Application no: 21/02337/DISC

Location: Proposed Himley Village North West Bicester, Middleton Stoney Road, Bicester, Oxfordshire

Transport Development Control

Condition 8 Masterplan and Design Code: Objection

PRIMARY ROAD

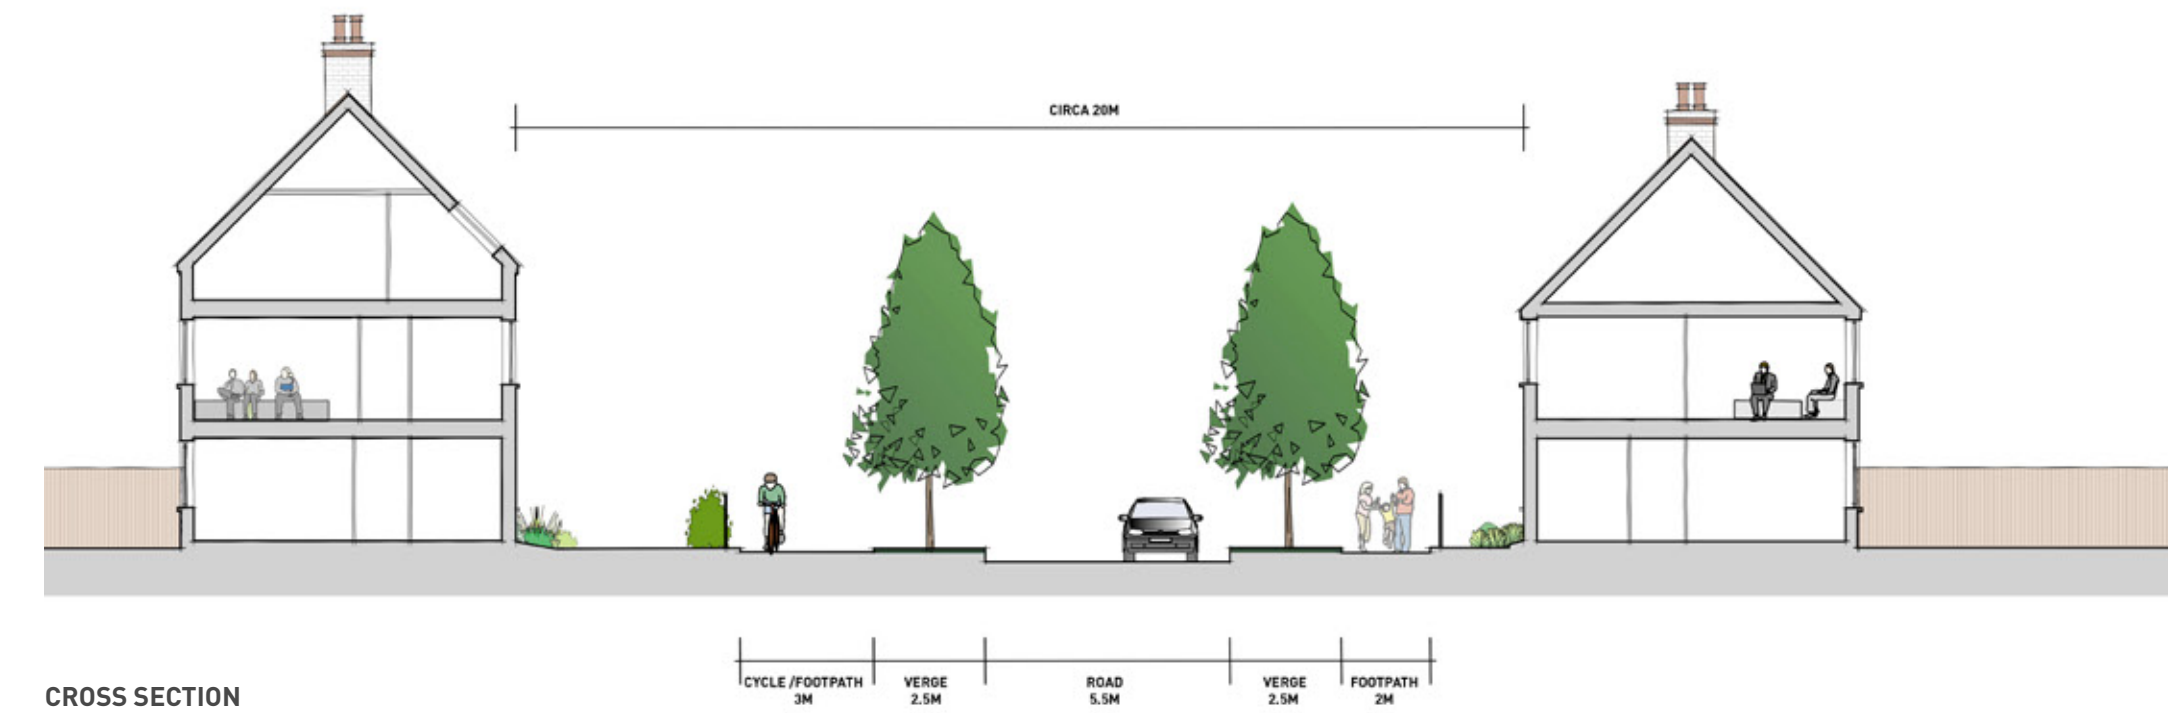
The typical Primary Street example (page 80) shows 3m wide shared-use cycle/footpaths on both sides but these need to be separate paths for pedestrians and cyclists to be in accordance with LTN 1/20. The Masterplan shows a "Pedestrian and cycle route" (red dots) on one side of the street only. Furthermore, the Primary Street cross-section gives a spacing between buildings as "Circa 30m" but the equivalent distance on the Masterplan is approximately 22m. It is a significant concern that this width will be insufficient to accommodate the necessary segregated cycling and walking facilities.
